STAGE 1A PUBLIC DOMAIN SSD 6303

Attachment A – Response to Submissions

Response to Schedule 1: Additional matters identified by the Department

Fig 3.13 Detail Plan - Transport Place

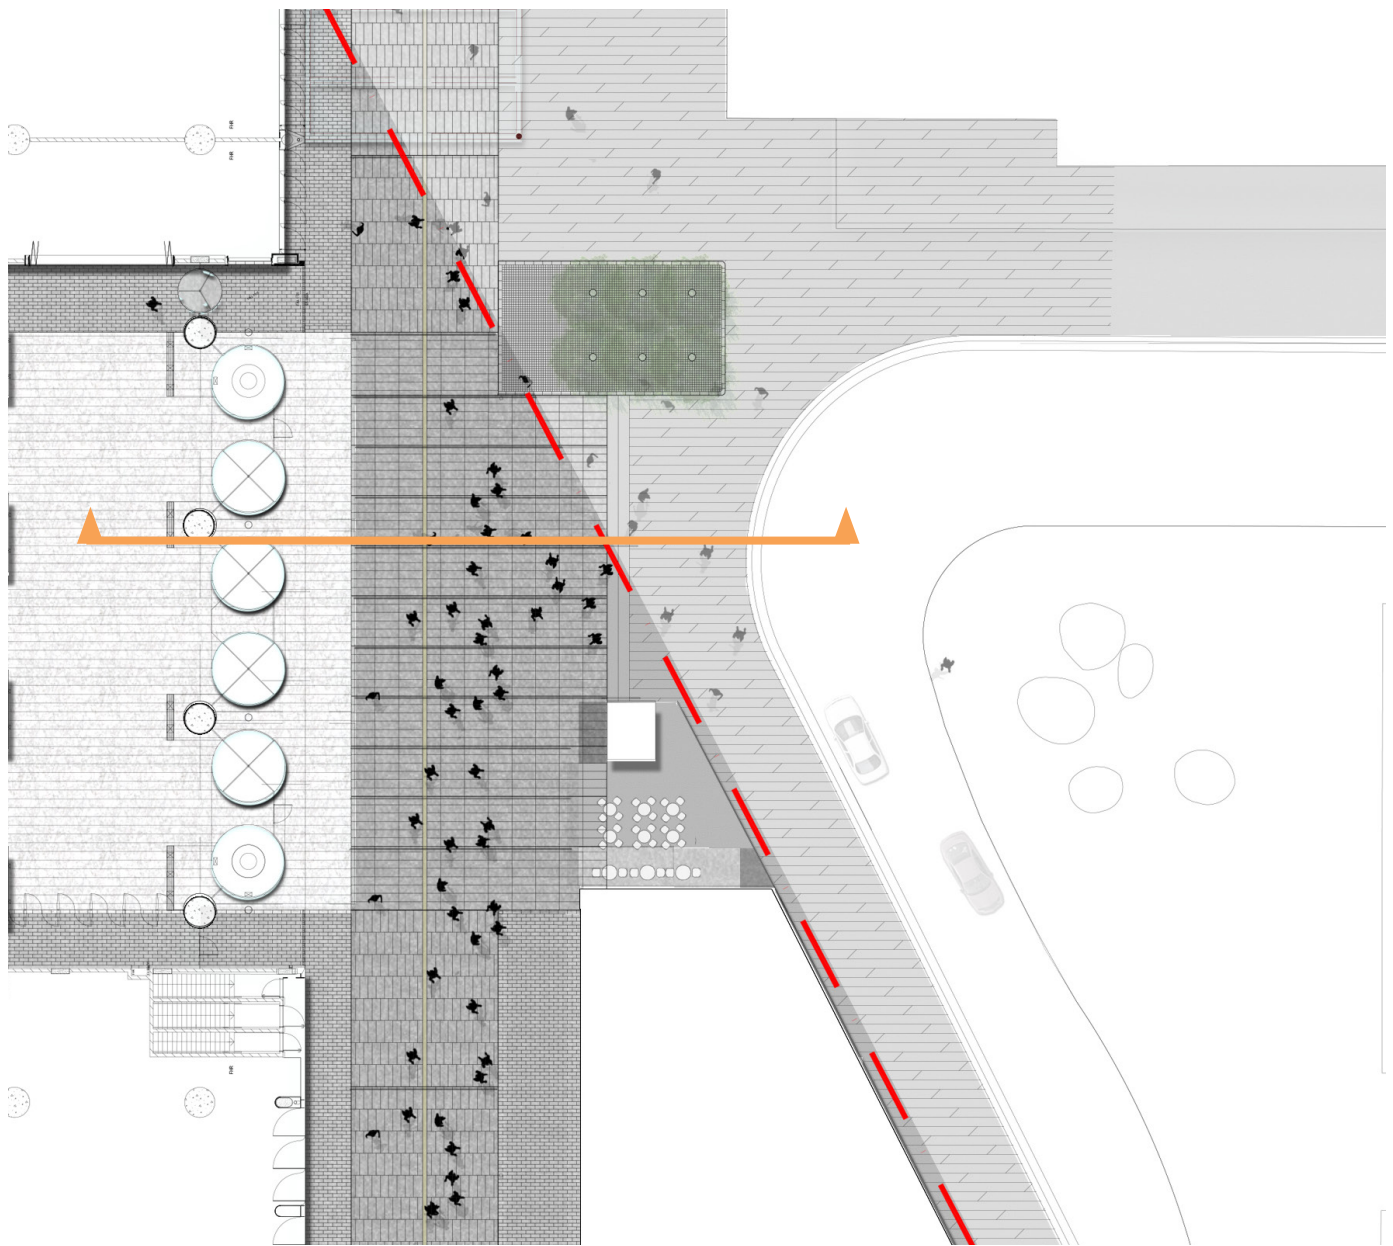
| Issue | Lend Lease Response |
|---|--|
| <p>The Concept Plan (as amended. Mod 6) includes the provision of street trees (secondary evergreen street trees) along the length of Transport Place. The Stage 1A public domain application significantly reduces the extent of tree planting in Transport Place, proposing that tree planting be limited to the Transport Place arrival space only. Justification for this change in strategy should be provided.</p> | <p>More detailed design investigations inherent in the Stage 1A Public Domain (and not undertaken at a Concept Plan level) have provided a clearer understanding of the opportunities and constraints present in the area. Specifically, the subsurface conditions with existing services and basement structure preclude tree planting except in planters as detailed in Section 4.3.1 of the EIS. It is noted that alternative solutions such as planters were considered and deemed not appropriate because of the spaces urban/civic nature and high pedestrian volumes. It is also noted that TfNSW's submission raised the importance of Transport Place providing an unobstructed connection between Wynyard Walk with the Ferry</p> |

**KEY**

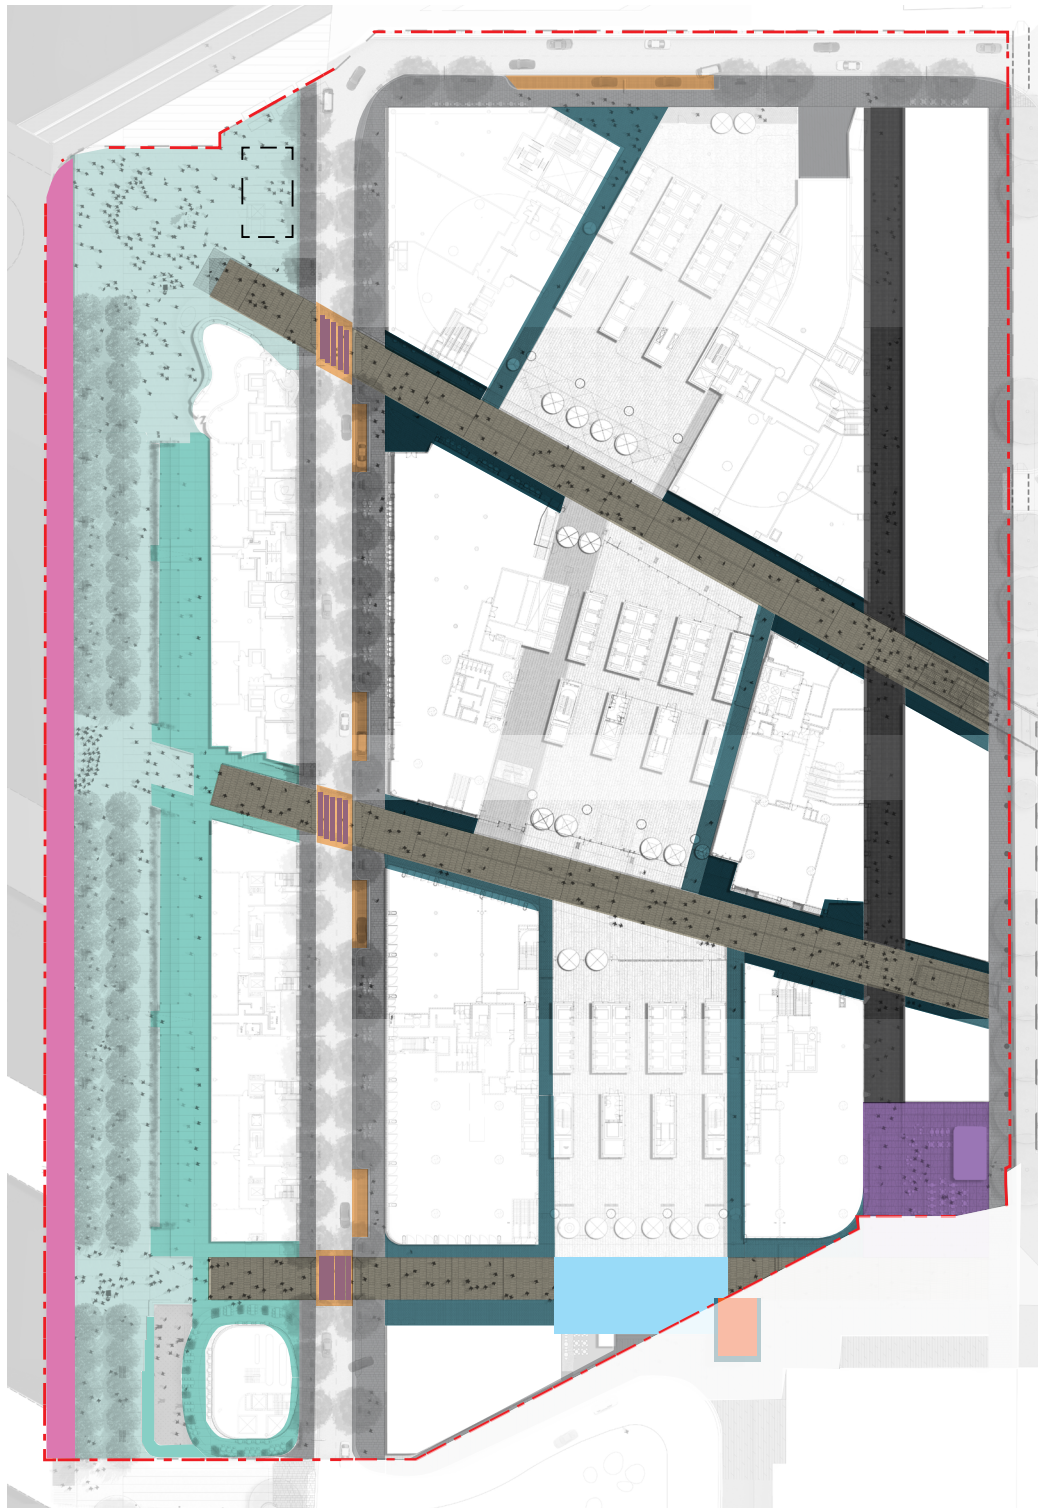
| Issue | Lend Lease Response |
|---|---|
| <p>The paving types identified in the Public Domain Stage 1A Landscape Report (refer Page 42) and Plan DA06 should be clarified on Plan DA205 and the 'detail' plans. The identification of the paving types on these plans are currently inconsistent and therefore, application of the paving types throughout the public domain is unclear. For example:</p> <ul style="list-style-type: none"> • The Hickson Place - 'special paving' detailed on DA321 is not shown on DA206. • Shelley Lane - paving detail on DA318 and paving types on DA206 are inconsistent / differently identified. | The Landscape Plans and Report (see Attachment B) have been updated to address the identified inconsistencies. |
